London Luton Airport Expansion

Planning Inspectorate Scheme Ref: TR020001

**8.140 Applicant's Response to Issue Specific Hearing 4
Action 7 - Update on M1 Junction 10 Road Safety Audit**

APPENDIX A – DRAFT STAGE 1 RSA DESIGNER'S RESPONSE M1 JUNCTION 10

Figure 5 Location of southbound merge markers

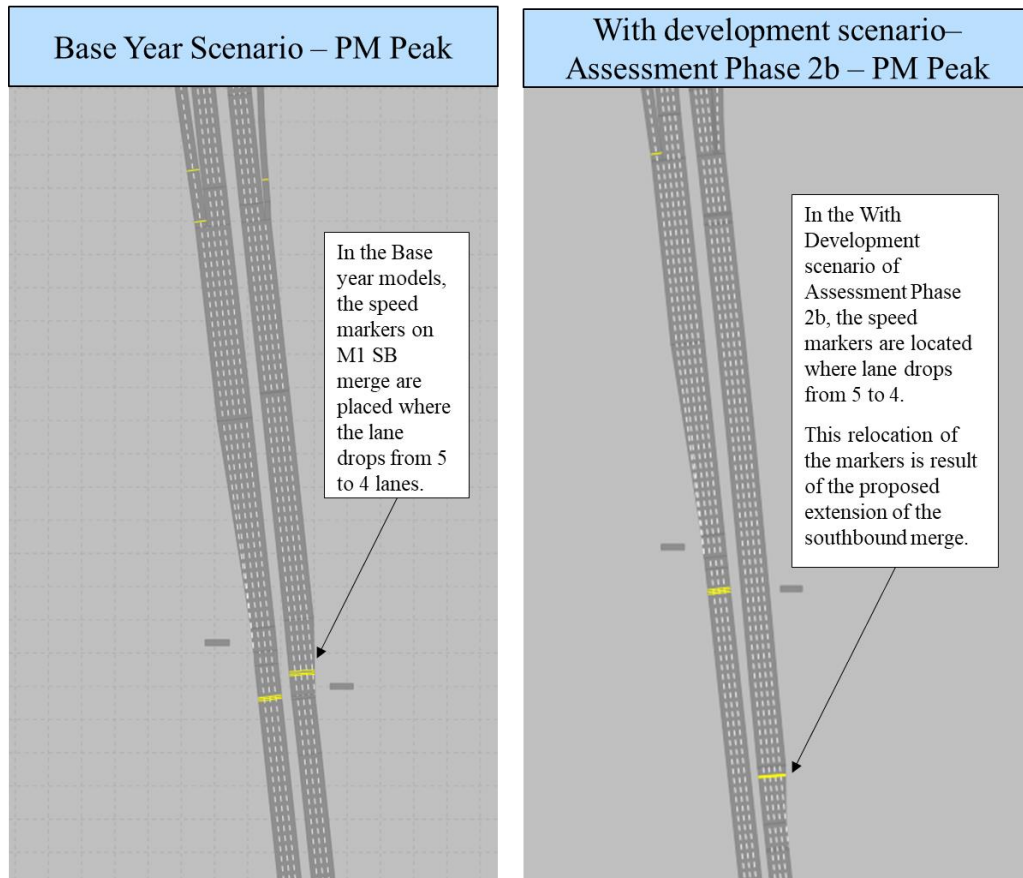
Ref.	RSA Problem	RSA Recommendation	Design Organisation Response	Overseeing Organisation Response	Agreed RSA Action
3.1	<p>Drawing LLADCO-3C-ARP-SFA-HWM-DR-CE-0009 indicates that the length of the two-lane merge is to be extended by 150m. This may result in forward visibility of the merge point being compromised by an existing hidden dip in the northbound on-slip.</p> <p>This problem increases the risk of side swipe and loss of control type collisions.</p>	<p>Ensure that sufficient forward visibility of the merge is maintained.</p>	<p>Accepted. Forward visibility would be checked at the detailed design stage to ensure that appropriate visibility of the merge is maintained.</p>	<p>Response to be completed following engagement with NH</p>	<p>Agreed action to be completed following engagement with NH</p>
